March 25, 2021

SH 21A/16A
El Paso County

RE: Security Fire Station 4_Subdivision Exemption
EA18135

# MESA RIDGE EMERGENCY ACCESS DRIVE STREET PLAN & PROFILE

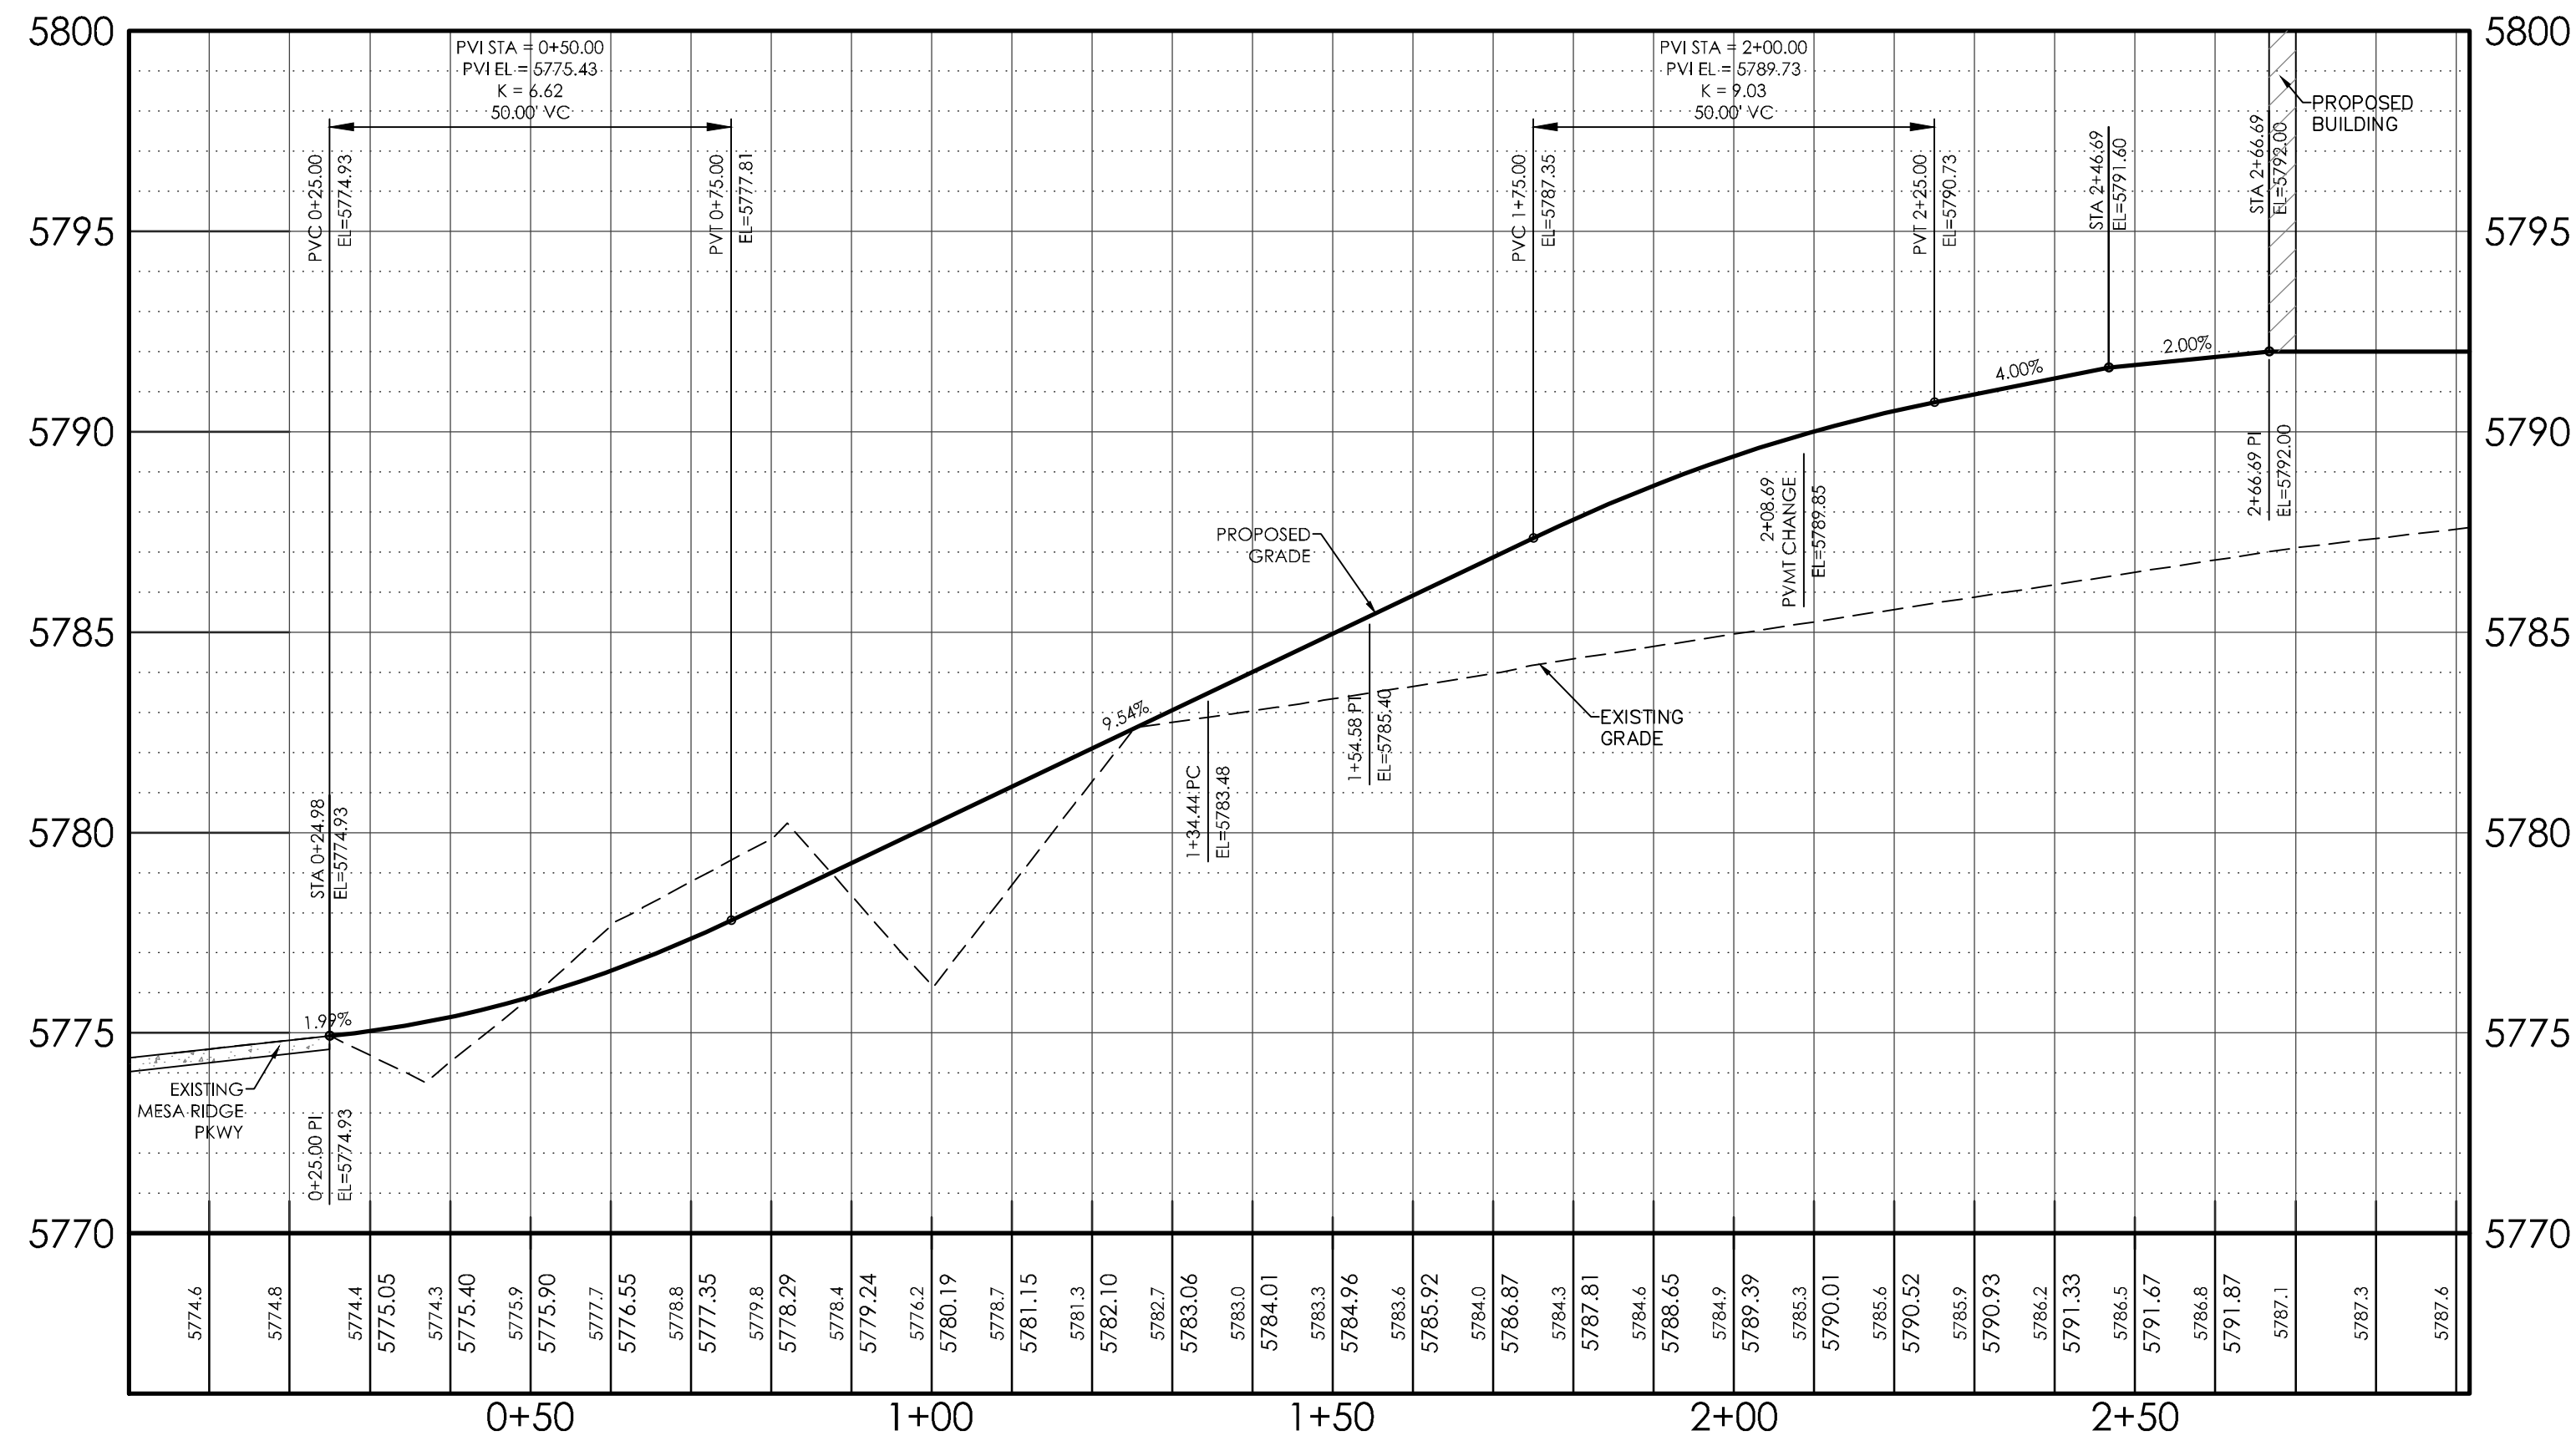
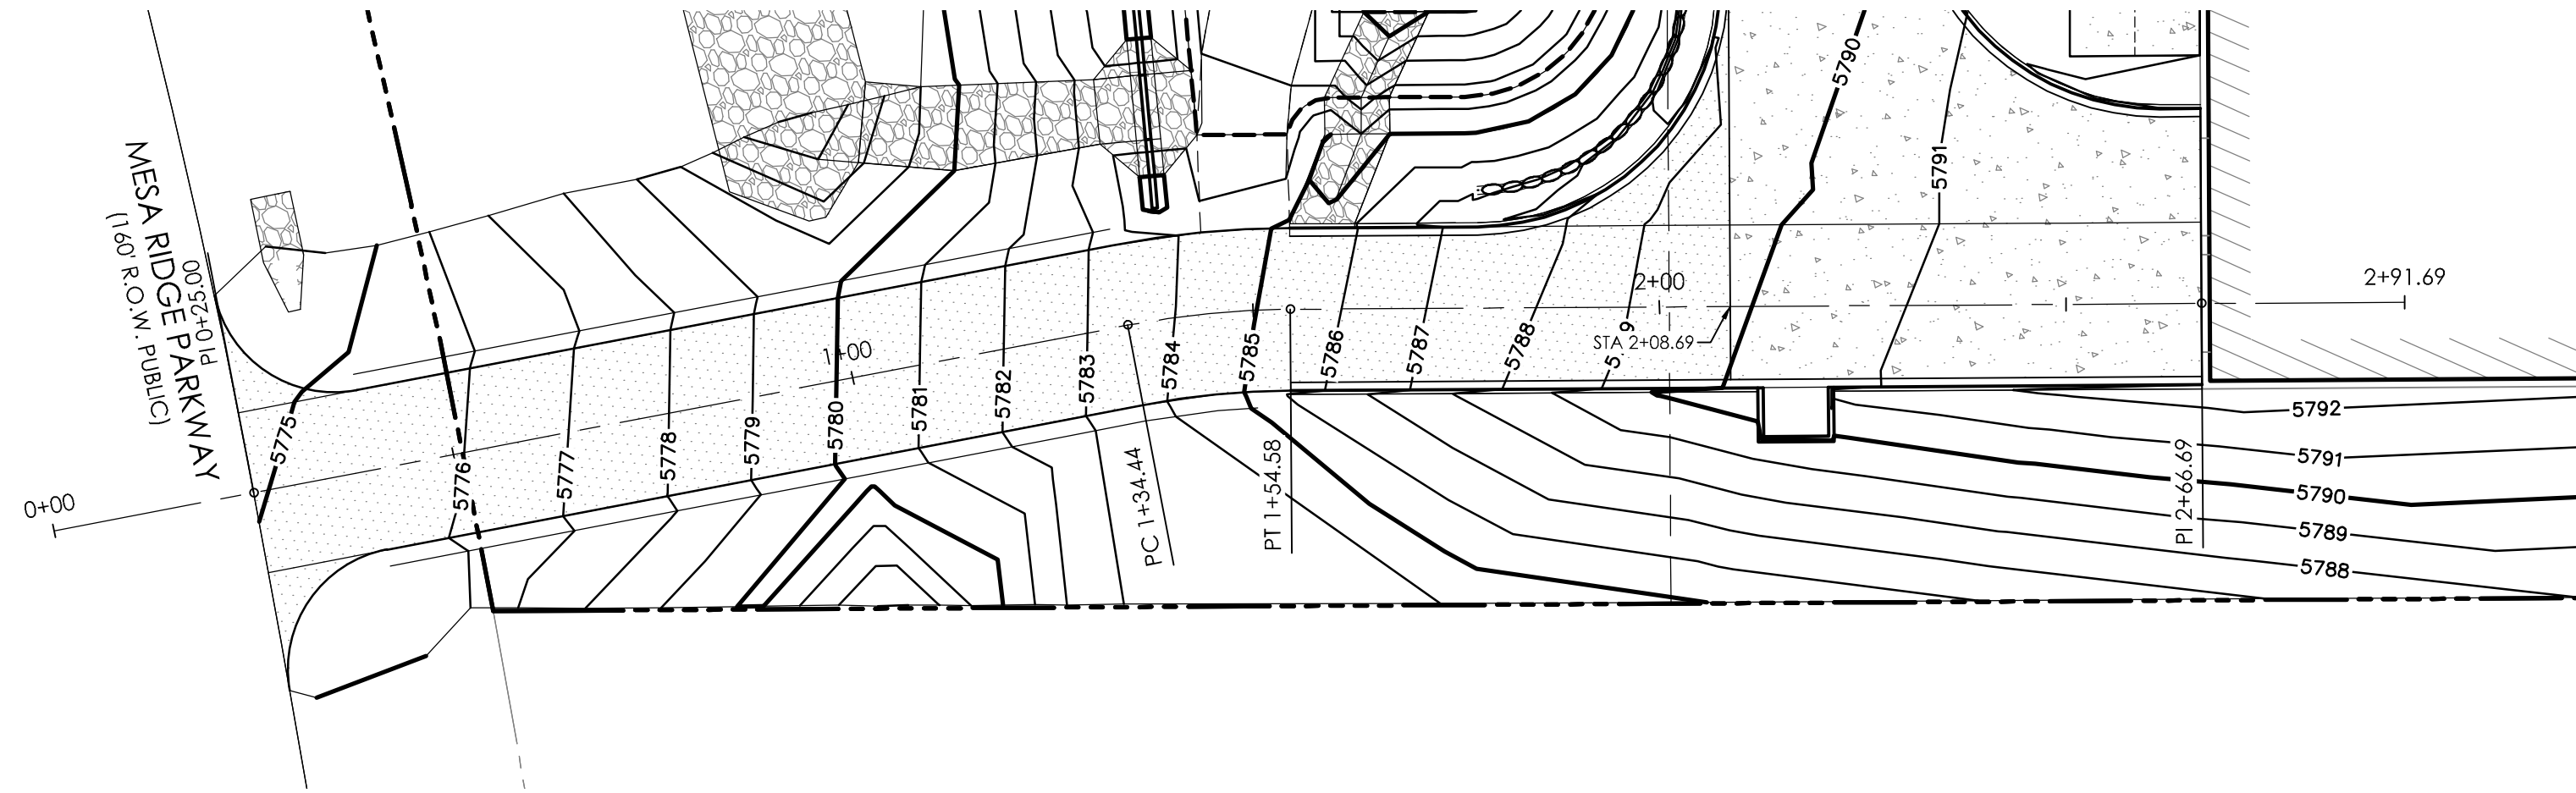
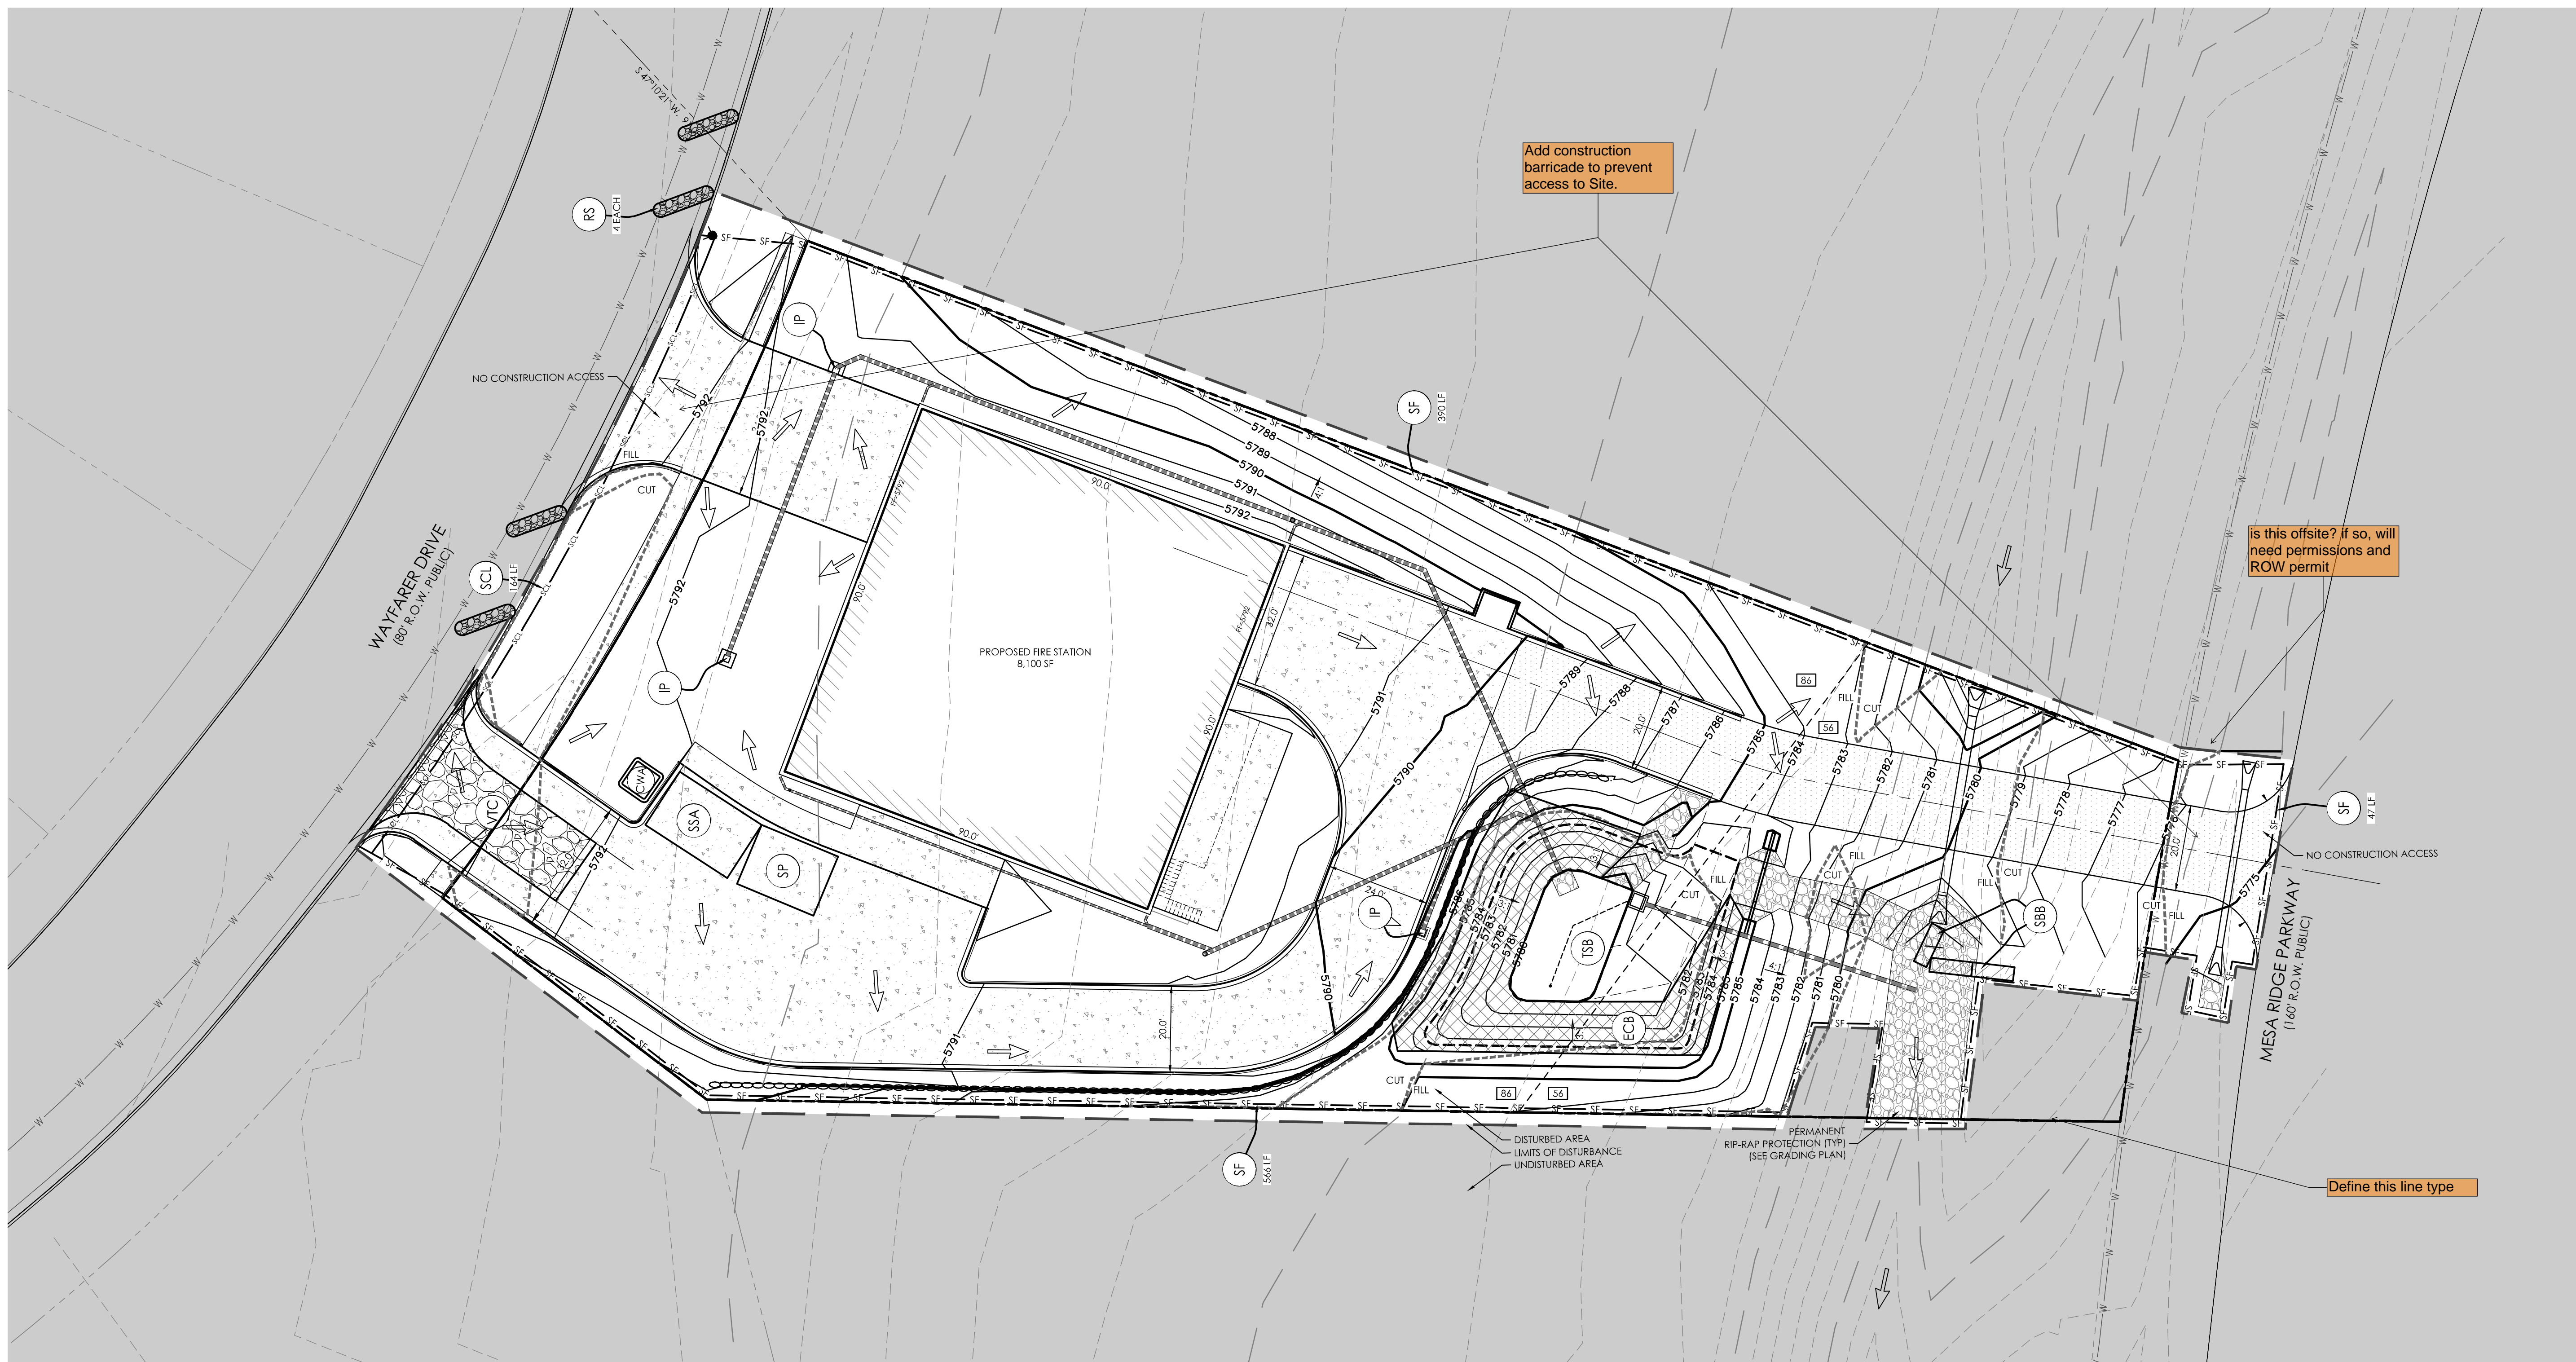
- Based on the location and expected minimal traffic volume CDOT will NOT require an access permit at this time.
- How will you ensure that the traveling public and non-emergency traffic will not make the Mesa Ridge Parkway access a thoroughfare?
- No direct access will be granted along the category F-W (Interstate System, Freeway Facility) State Highway 21 (Powers Blvd) now or in the future for any purposed improvements to the property without Federal Highway Administration approval. .
